**WELWYN HATFIELD BOROUGH COUNCIL
EXECUTIVE DIRECTOR - PLANNING, PUBLIC PROTECTION AND GOVERNANCE**

Application No: 6/2020/0851/LAWP
Location: 40 Vineyards Road Northaw Potters Bar EN6 4PA
Proposal: Certificate of lawfulness for the installation of 2x front facing roof lights and 2x rear dormers to facilitate loft conversion
Officer: Mr Tom Gabriel

Recommendation: Refused

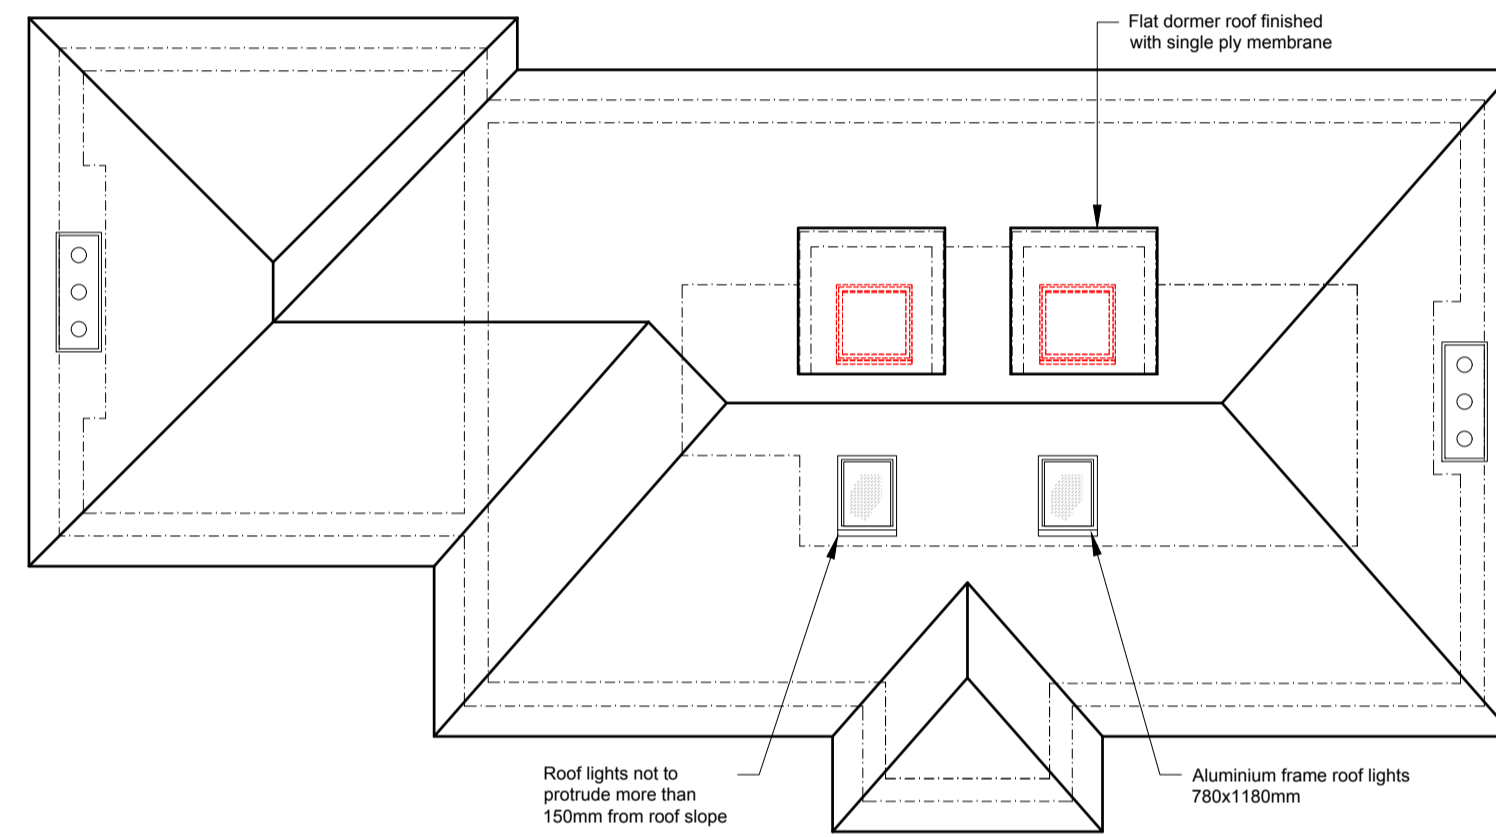
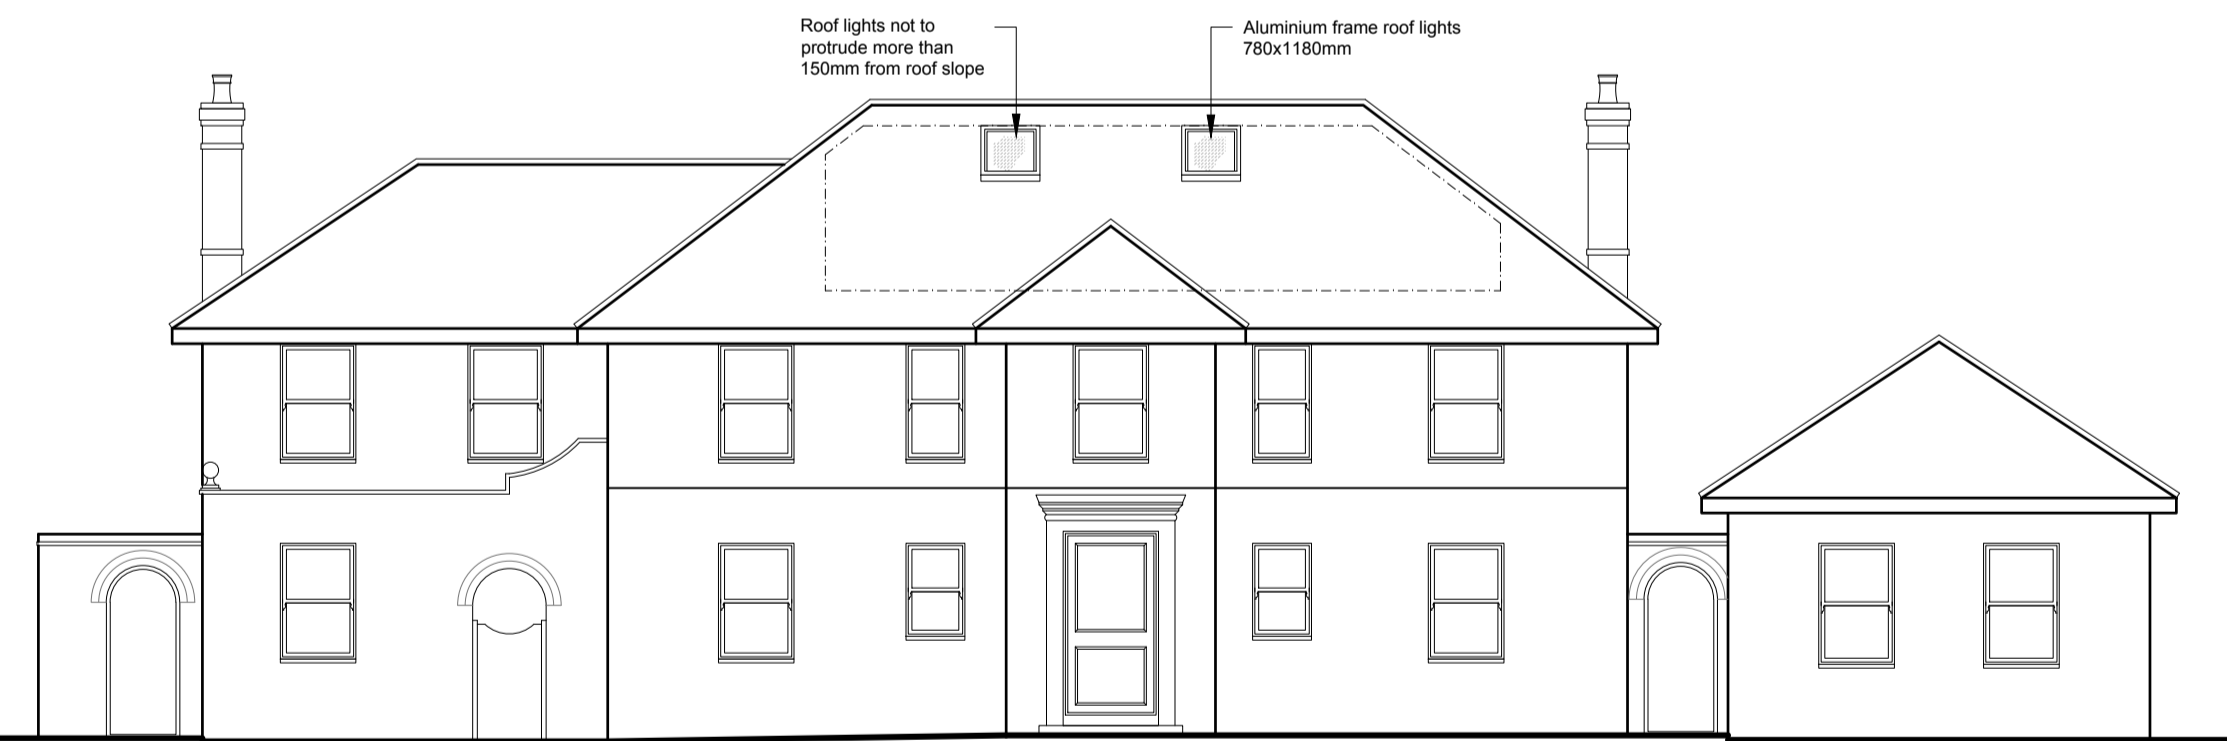
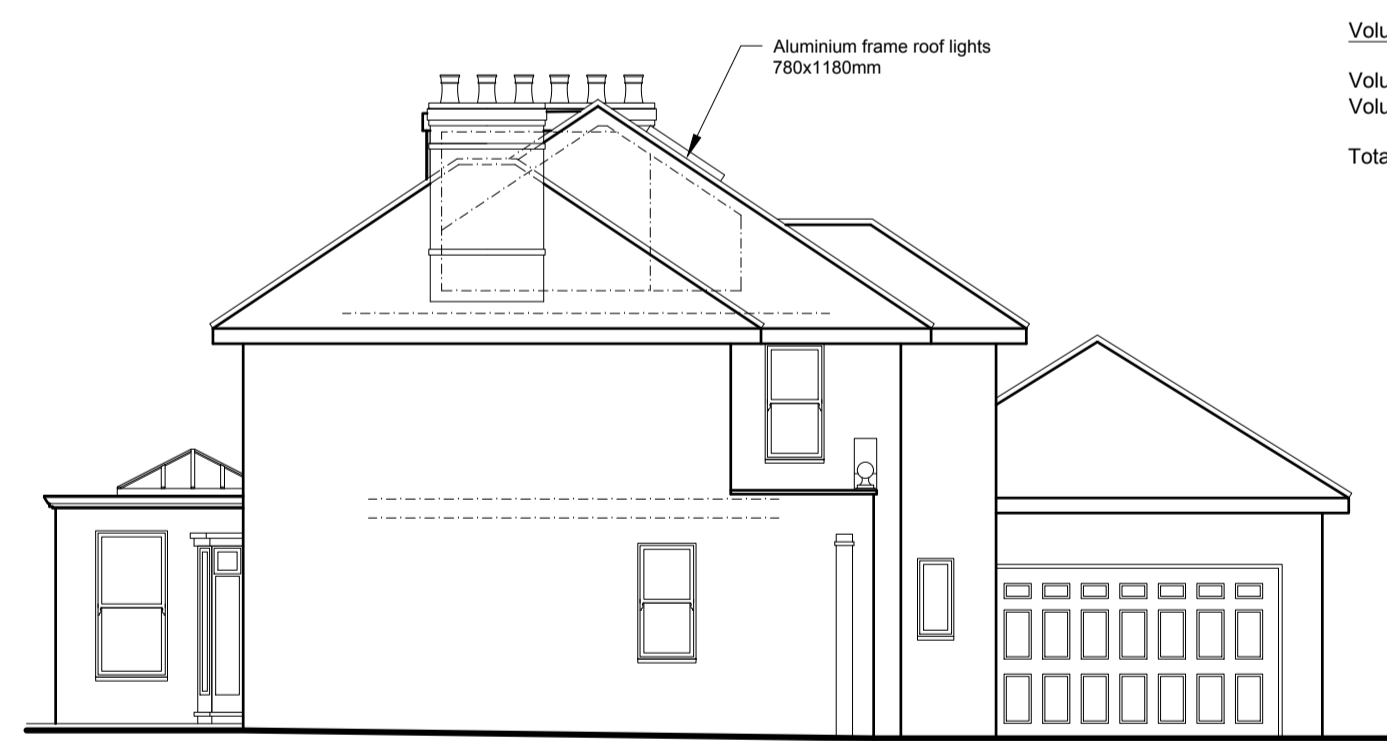
(d) would the cubic content of the resulting roof space exceed the cubic content of the original roof space by more than:- (i) 40 cubic metres in the case of a terrace house, or (ii) 50 cubic metres in any other case	Y see below	N
<p><u>Calculation</u></p> <p>Volume of existing roof extension/ alterations;</p> <p>The main roof over the side extension –</p> $(2.46 \text{ (h)} \times 6.6 \text{ (d)} \times 5.33 \text{ (w)}) / 2 = 43.25\text{m}^3$ <p>The section of roof resulting from the projection of the rear wall of the side extension -</p> $(2.46 \text{ (h)} \times .66 \text{ (d)} \times 6.4 \text{ (w)}) / 2 = 5.2\text{m}^3$ <p>Total volume of existing roof extension/ alterations = 48.45m³</p> <p>Proposed dormers: $(1.2 \text{ (h)} \times 2 \text{ (d)} \times 2.1 \text{ (w)}) / 2 = 5.04 \text{ m}^3$</p> <p>Total = 53.49 m³</p>

The proposal has been assessed against and fails to comply with the conditions and limitations of Schedule 2, Part 1, Class B of The Town and Country (General Permitted Development) Order 2015 (as amended).

1. The proposal has been assessed against and fails to comply with the conditions and limitations of Schedule 2, Part 1, Class B of The Town and Country (General Permitted Development) Order 2015 (as amended).
